Cover Letter - Response to Notice of Incomplete Application for SHL23-014 and SEP23-003 (Evers Pier Repair).

Planning comments with WCI responses in red below:

EXISTING SITE PLAN

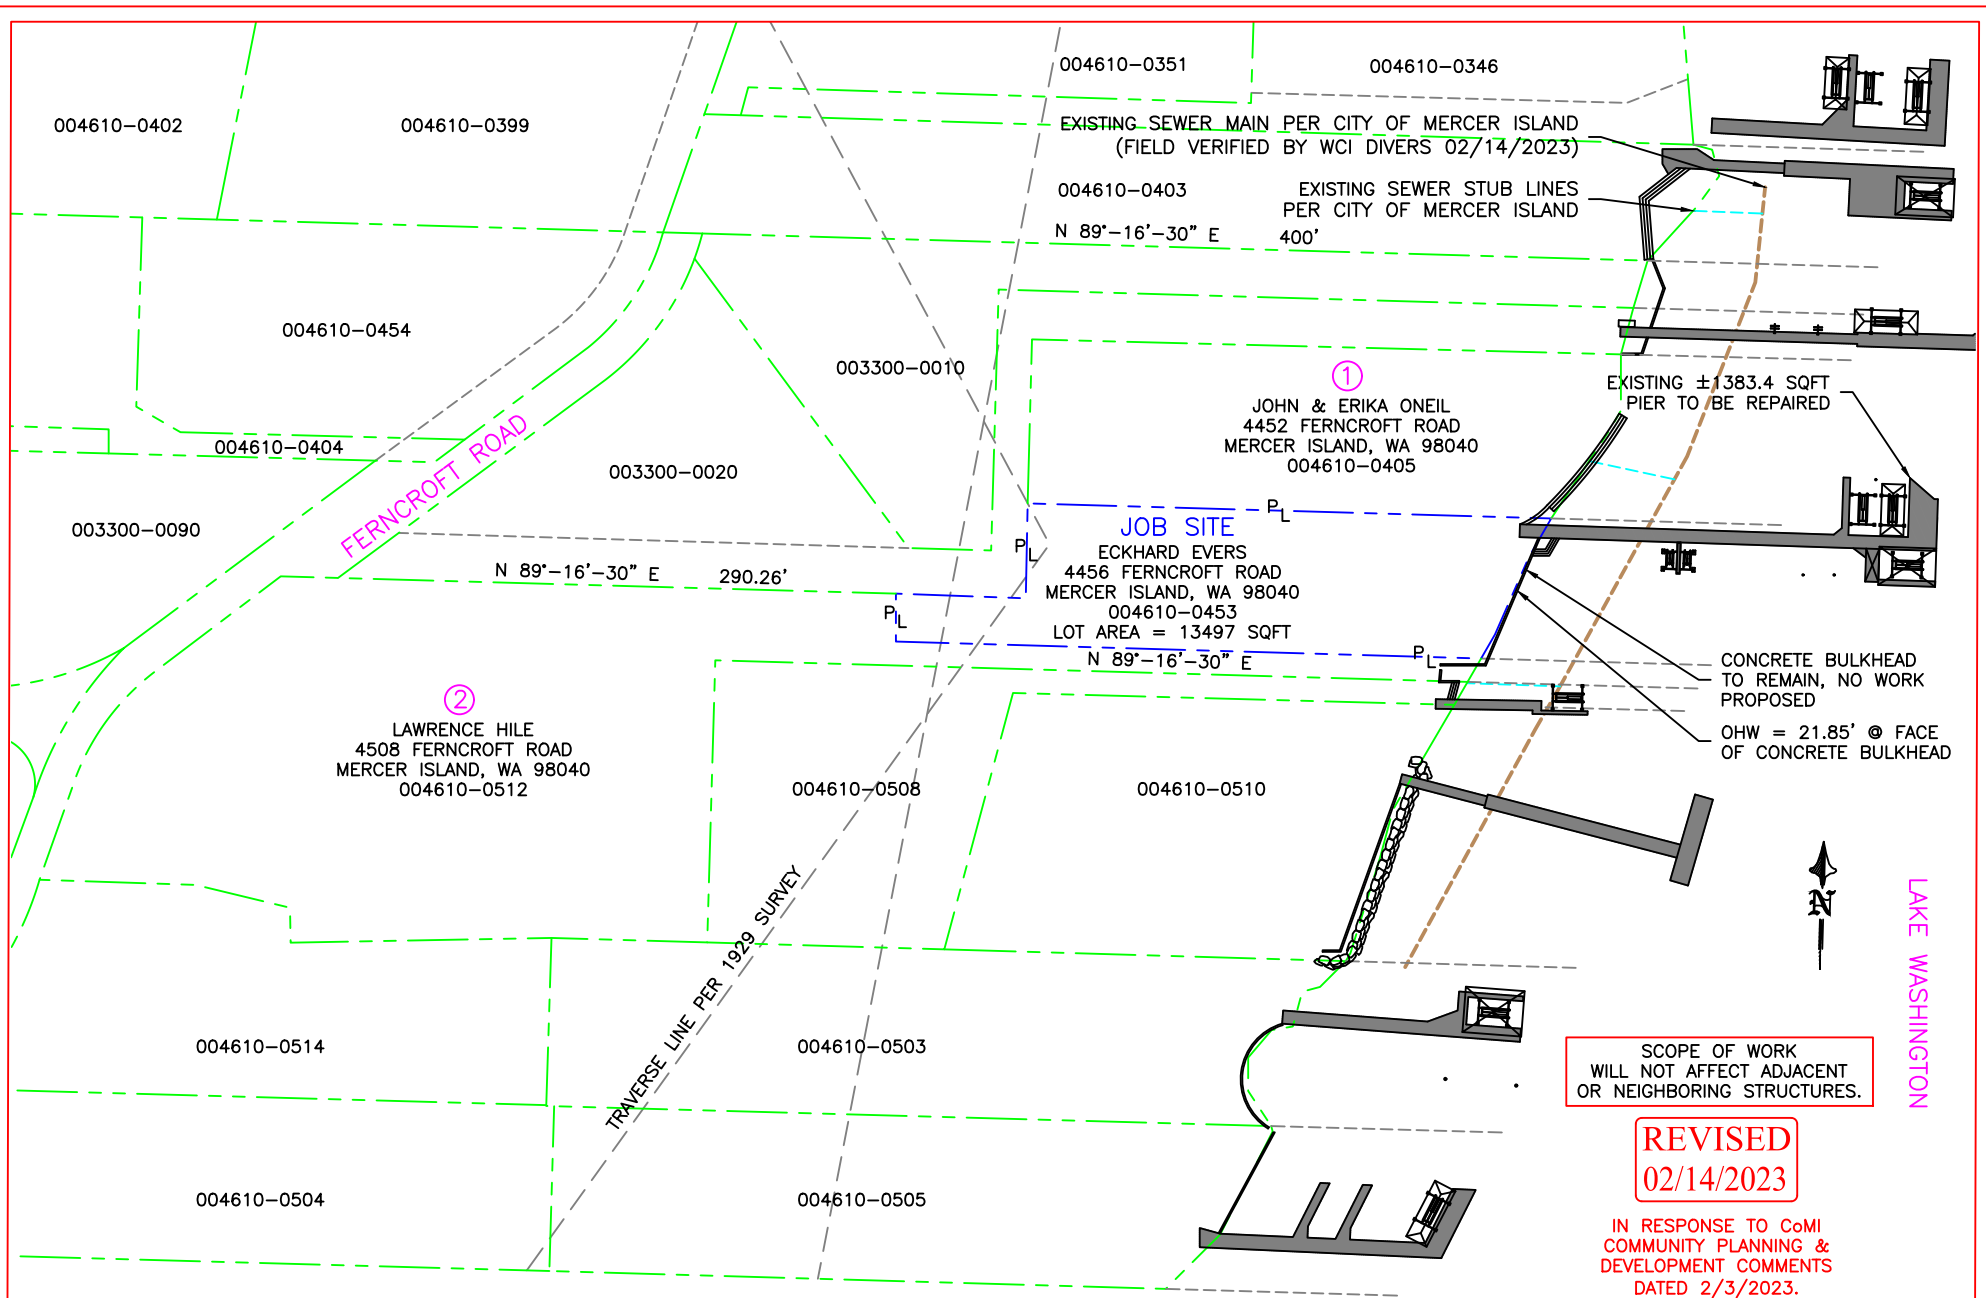
2. The provided Sewer Lake Line Affidavit is not filled out. Please submit a copy of the Sewer Lake Line Affidavit that is fully filled out, signed, and notarized.

WCI Response: A copy of the fully filled out, signed and notarized Sewer Lake Line Affidavit is attached. In addition, the sewer lake line has also been field located and added to the plan set, please see revised plan set (dated 2.14.2023), pages 2 and 3.

EXISTING SITE PLAN DETAIL

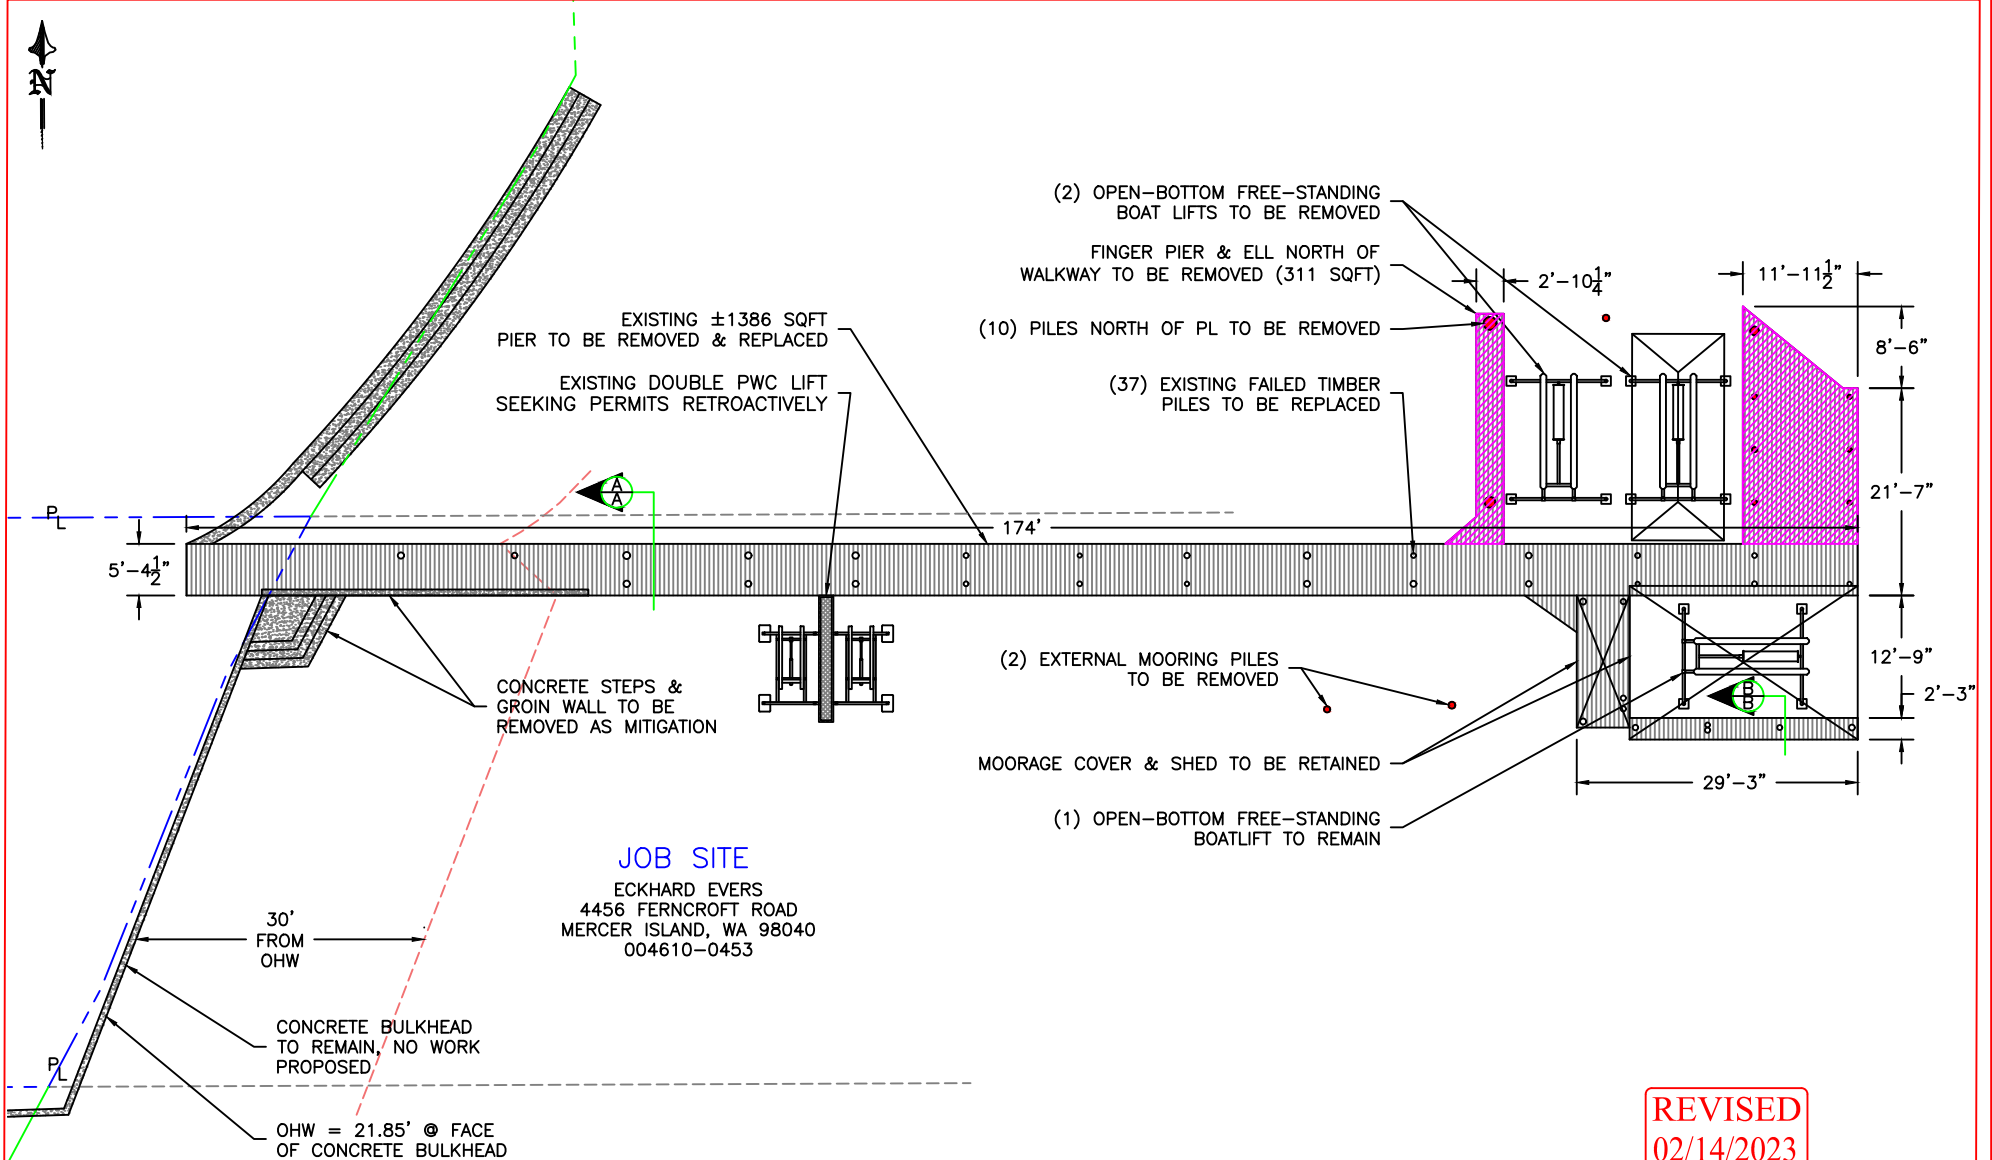
3. Aerial imagery shows that the personal watercraft lifts and associated finger pier on the south side of the pier were installed between 2009 and 2012. However, there is no record that these elements received permits from the city. Please include the personal watercraft lifts and the finger pier in the scope of work for the proposed Shoreline Substantial Development Permit.

WCI Response: The mentioned structure is a double personal watercraft lift, not two single personal watercraft lifts and a finger pier. The double personal watercraft lift was included in the initial SSDP application (please see SEPA checklist Question A.11, page 3), however, it was not mentioned in the PDCS (project description, construction sequence) or plan set. Please see attached for revised PDCS and plan set dated 2.14.2023, pages 4,5 and 6 with the double personal watercraft lift included in the proposed scope of work.
